Application number: 2023/93715	
What is the application for?:	Alterations to and change of use of teaching institute (use class F1) to form 11
Address of the site or building:	Waverley United Reformed Church, Waverley Road, Huddersfield, HD1 5NA
Postcode:	HD1 5NA

User comments

Project Name Waverley Church, Waverley Road, Huddersfield, HD1 5NA	
Drawing Title: Option 4-Proposed Elevations	
Drawing Number: TR-A23-0802-006	Scale: 1 : 100@A1
Date: 23/07/24	Revision: G
Drawn By: AM	Checked by: JA
Reason For Issue: Planning

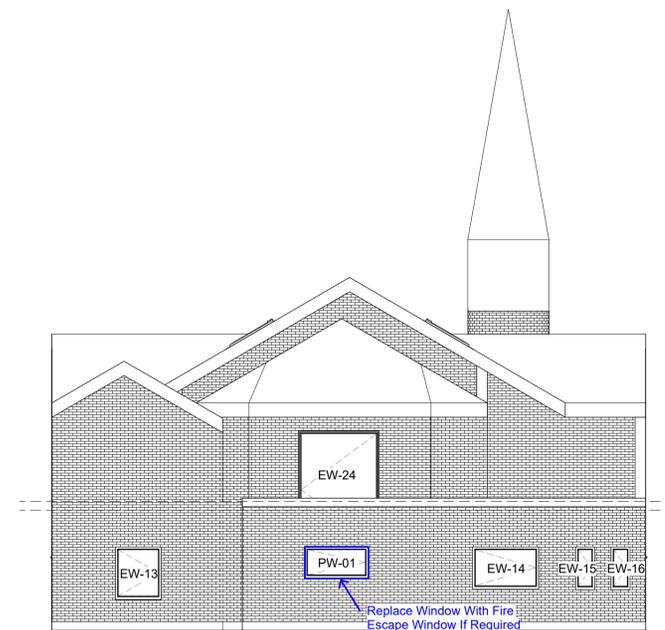
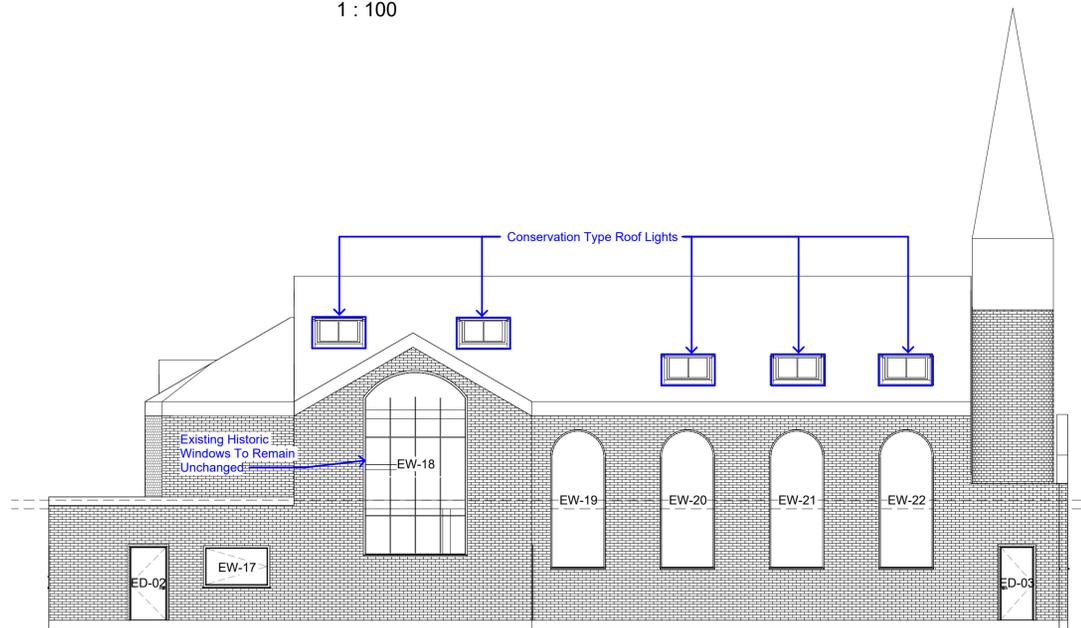
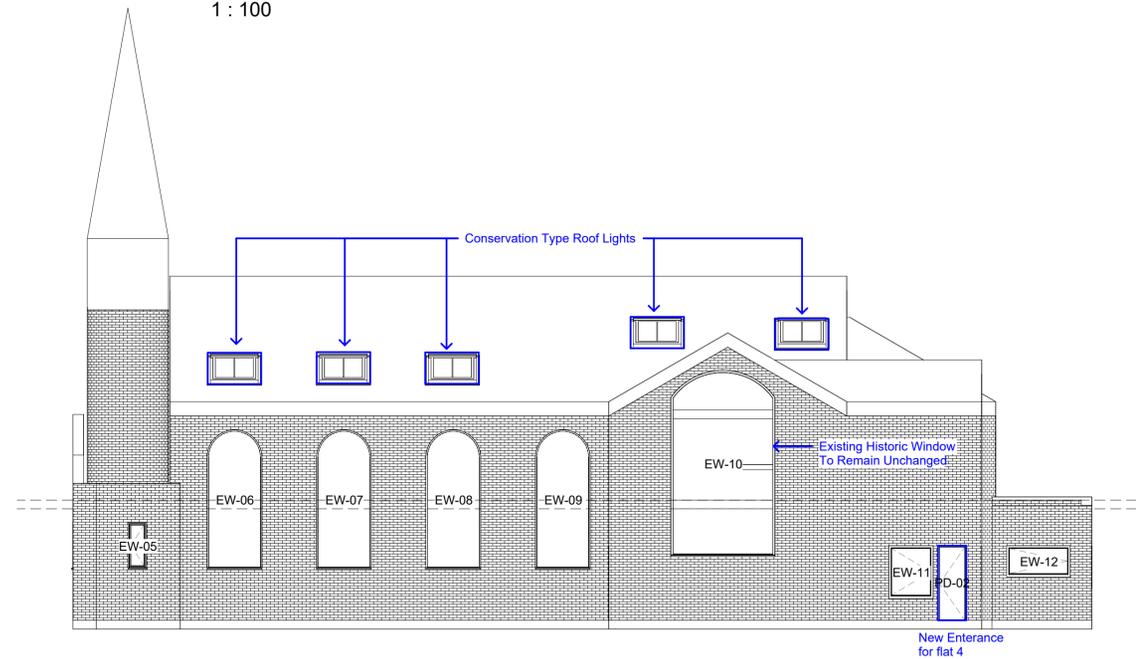
Type of comment: An objection	
Do you wish your comments to be published on the website anonymously?	Yes
<p>On behalf of Huddersfield civic society :- Firstly we fully support the principle of a conversion suited to living accommodation. However we note a distinct lack of detail knowing this is a building of significant historic interest and sits within the conservation area. The existing trees are omitted from location/site ground plans given that the land sits within the local conservation area and all those trees will have a protection order. Possibly insufficient parking spaces for 11 apartments and we possibly would question the statement "No significant impact" given the alterations to doors and skylights. A Heritage assessment may be required.</p>
